DECISION DELEGATED TO HEAD OF PLANNING

Application No: H16-0437-24 **Applicant:** Country Court Care Ltd

Proposal: Erection of two storey rear extension to provide additional bedrooms, day space, storage, nurses station, assisted bathrooms and additional car parking spaces

Location: Ashwood Nursing Home 43 Spalding Common Spalding

Proposed First Floor Layout
1:100

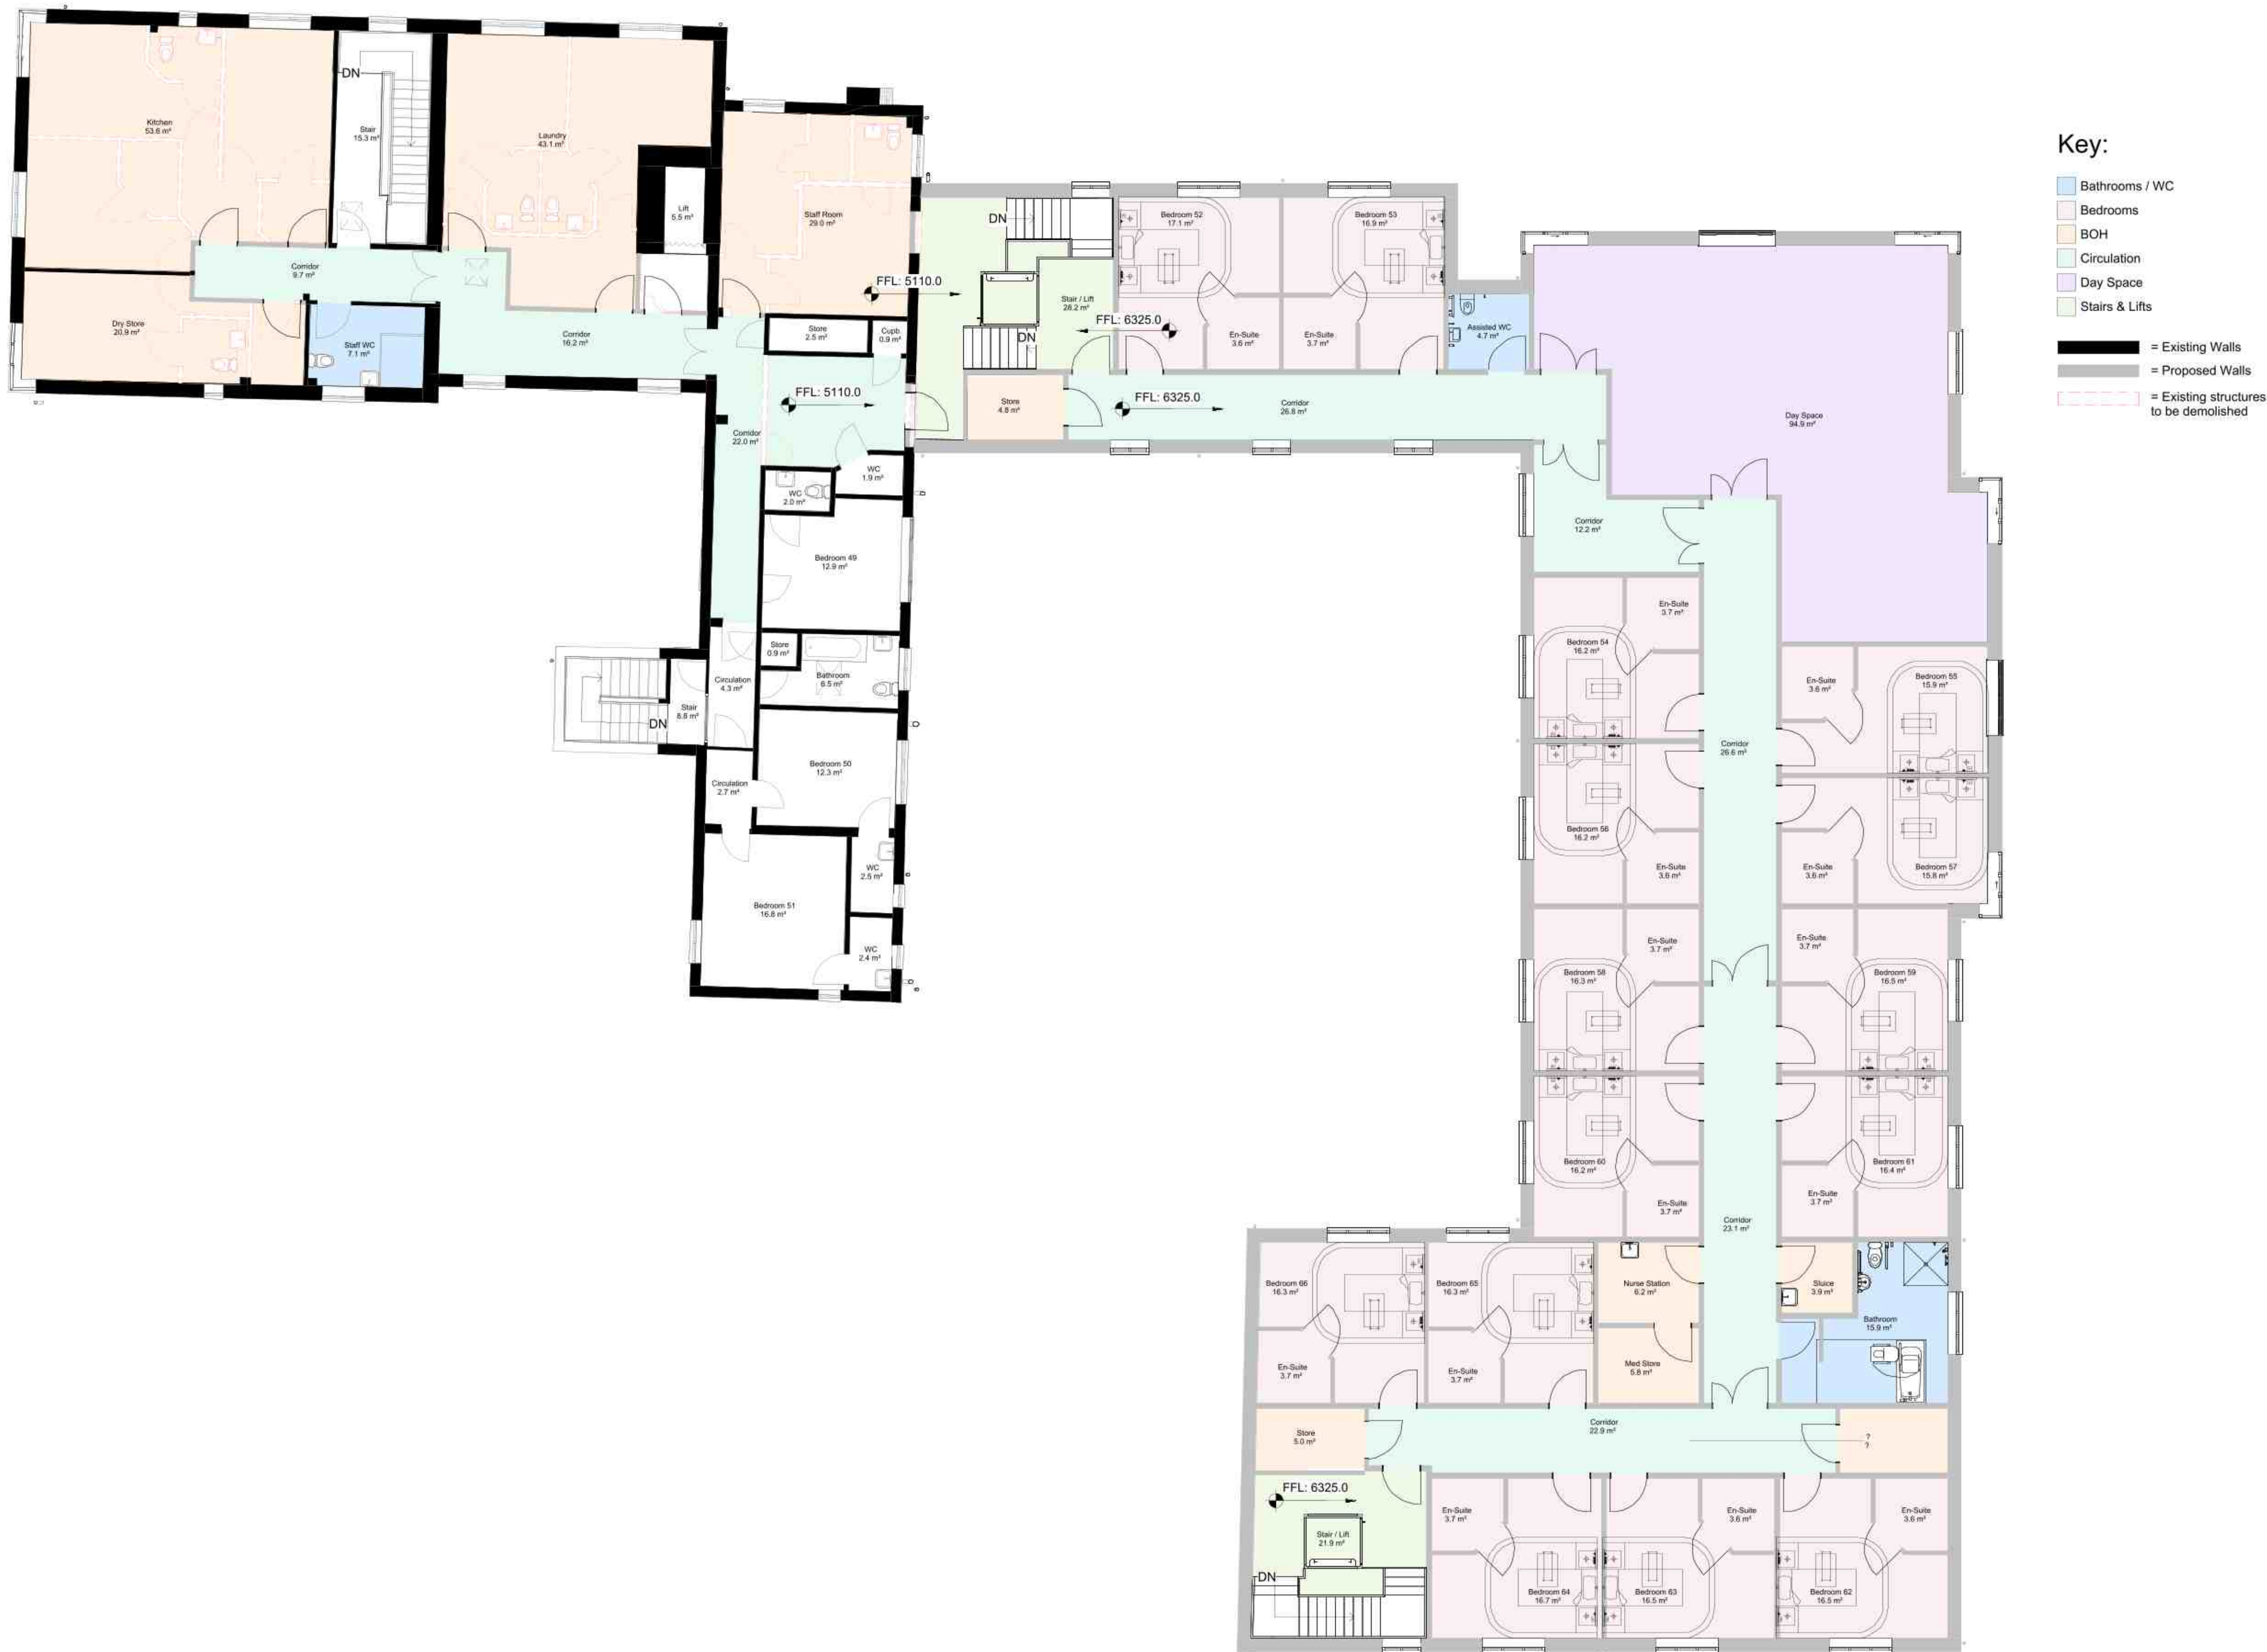
The amended ground floor and first floor plans provide clarify on how the proposed raised finished floor levels are to be achieved, via stairs and a lift.

At first floor level a further 15 bedrooms are proposed, with 2 stores, an assisted toilet, a further day space of 99 square metres, a nurses room, a med store, a bathroom and a sluice. Some of the bedrooms have integrated en-suites. At first floor level, amended plans have removed windows from two of the bedrooms closest to the neighbouring property, as a result of concerns expressed by the case officer in terms of potential overlooking.

Title: BIA Retention Habitat Plan		
Project: Country Court Care Homes		
Plan Ref: 0443 (10)002 - Proposed Site Plan (1)		
Client: Ashwood Care Home		
Date: 08/05/2024	Fig:	Author: RD
A4 Scale: 1:400	ID: RSE_8039_BIAR_0524_V1R2

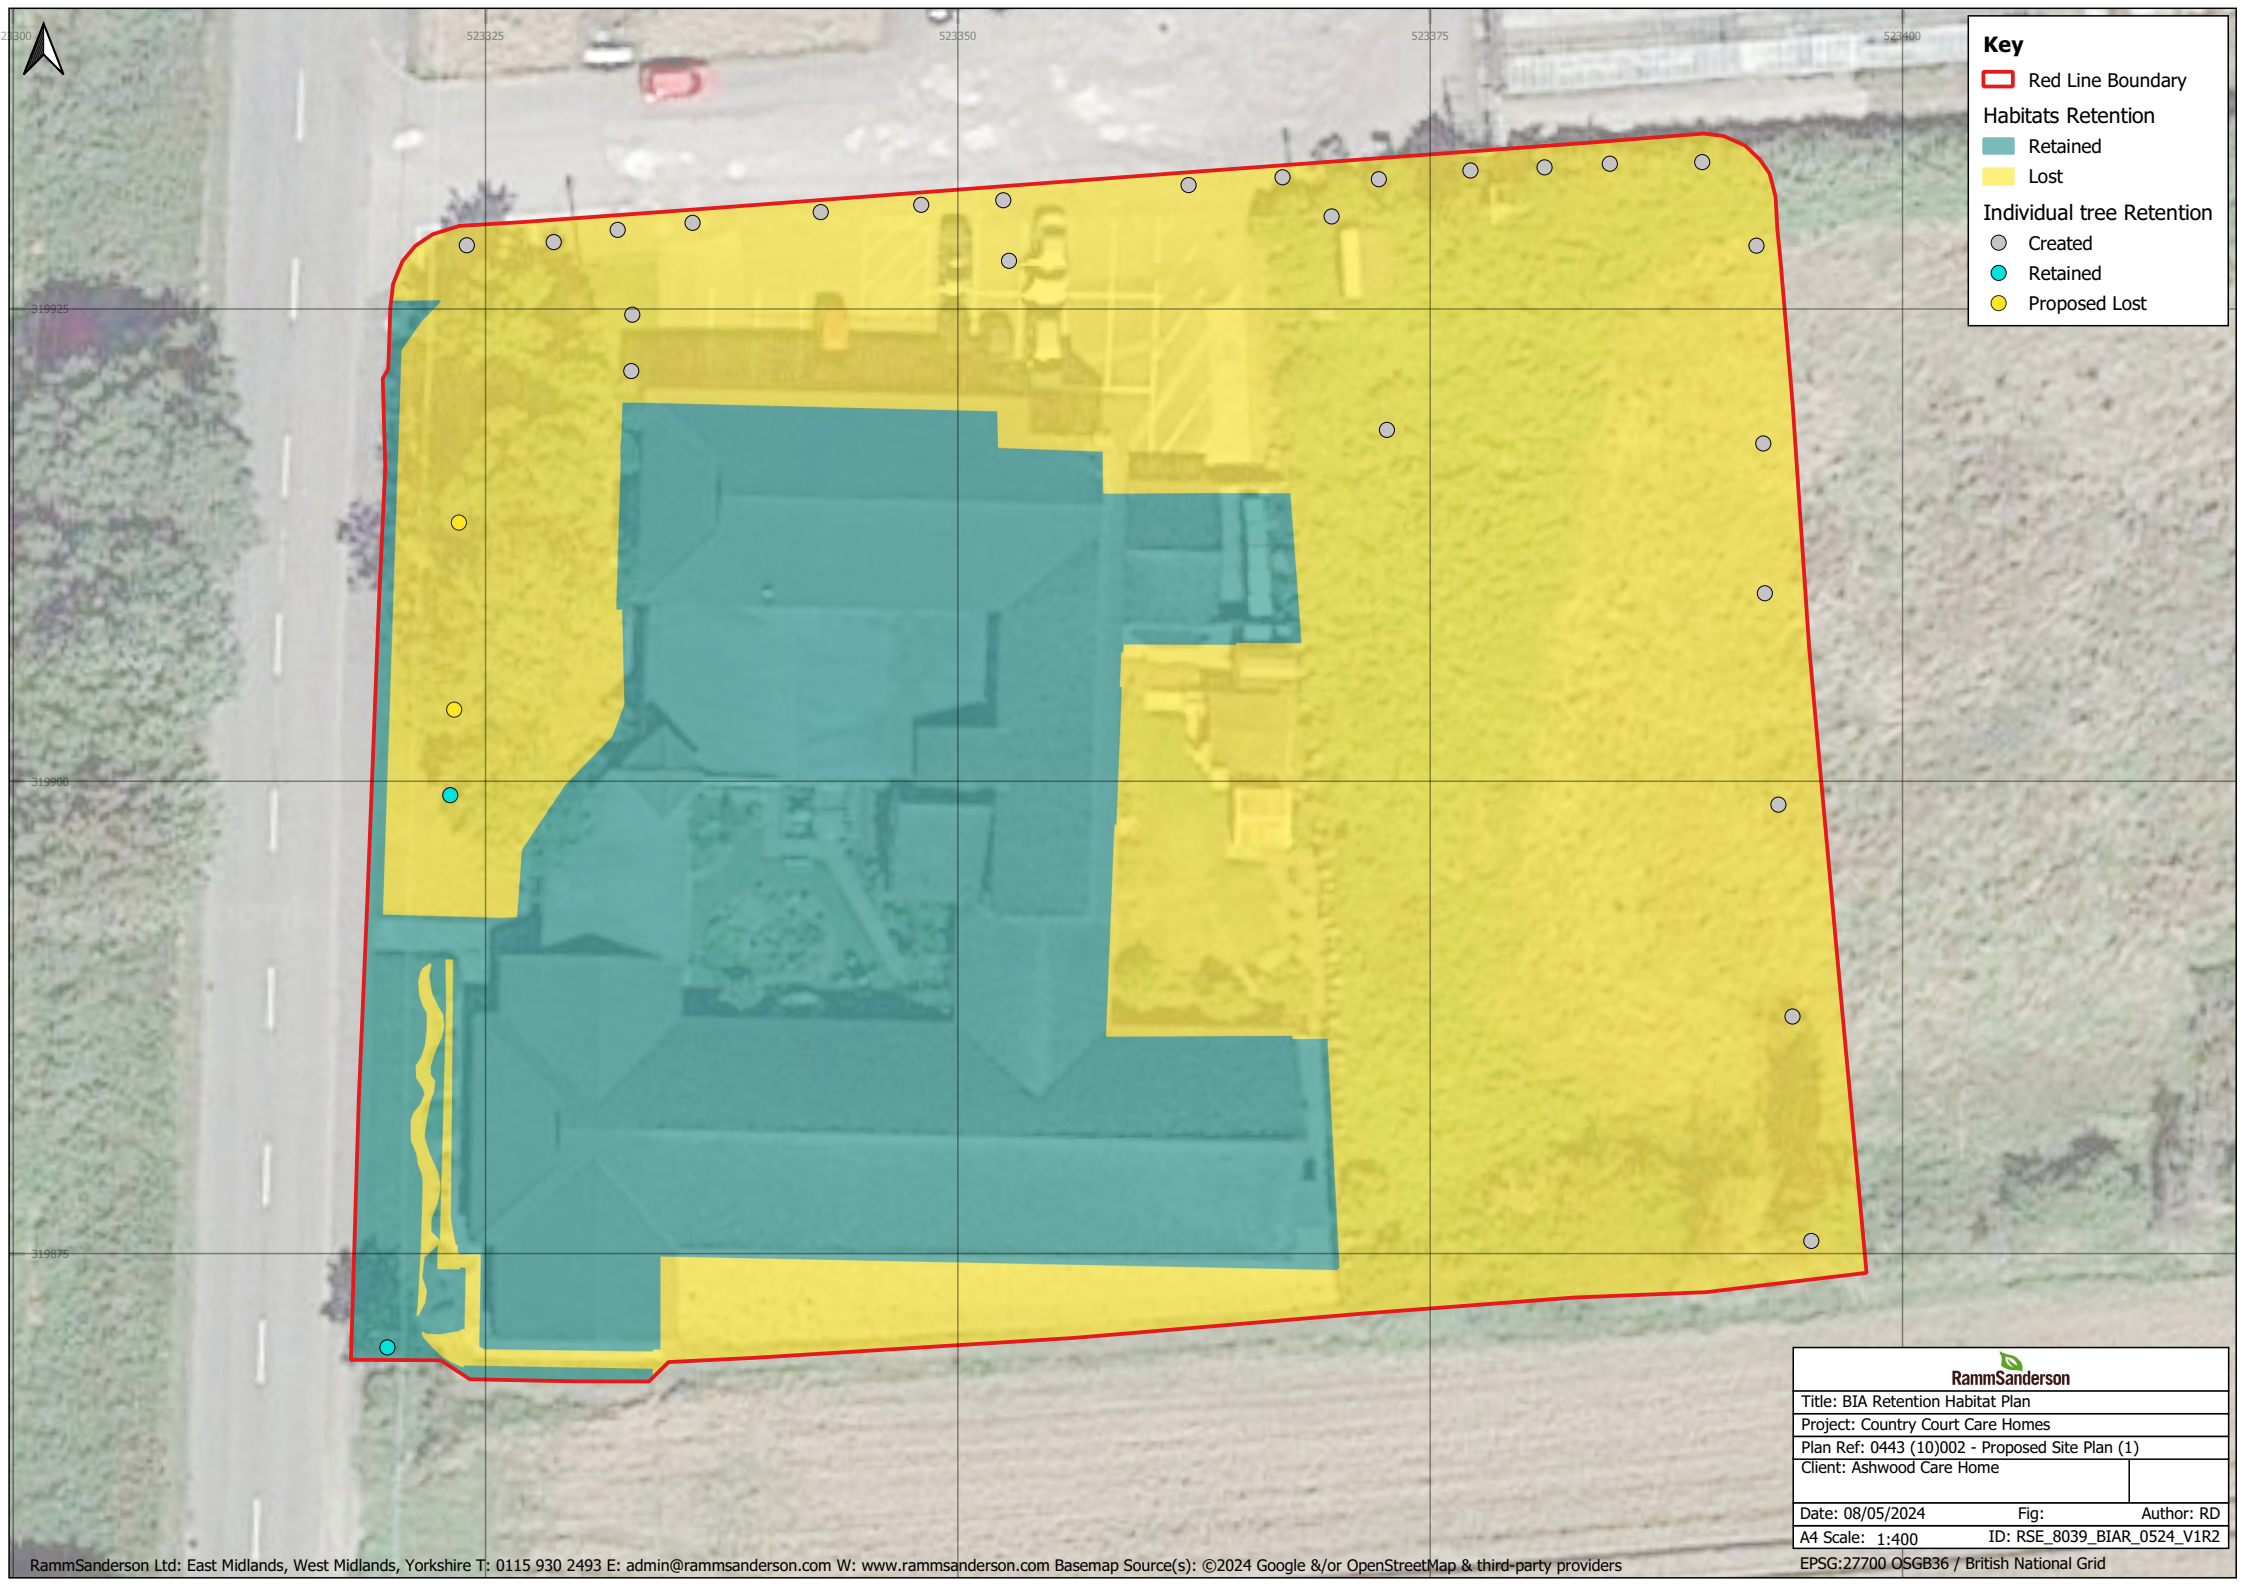
1. Habitat maps pre- and post-development require clearly labelled identifiers for each habitat parcel/type with which to link information within the Defra metric tool to the corresponding habitat parcel. Currently, these maps do not provide a label/identifier to easily link and compare this information pre- and post-development.

2. The proposal includes establishing 0.0285 ha of "other neutral grassland" in "moderate" condition on the east side of the extension. This proposed habitat and condition will require specialized management to obtain (e.g., soil testing and nutrient management and disturbance mitigation). This is not feasible to obtain on the site and within the level of disturbance expected within the grounds of a nursing home without strict management measures. The applicants would have to submit a habitat management and monitoring plan (HMMP) pre-commencement for us to review and agree to. If we consider the HMMP to be unfeasible, then they will not be able to discharge the BNG condition and the development would be subject to a stop notice or other enforcement procedure.

A S106 agreement for BNG is not required because the value of biodiversity gains fall below our current definition of 'significant'.

A HMMP condition should be imposed to require them to submit a HMMP along with their

biodiversity net gain plan to discharge the biodiversity net gain as pre-commencement.
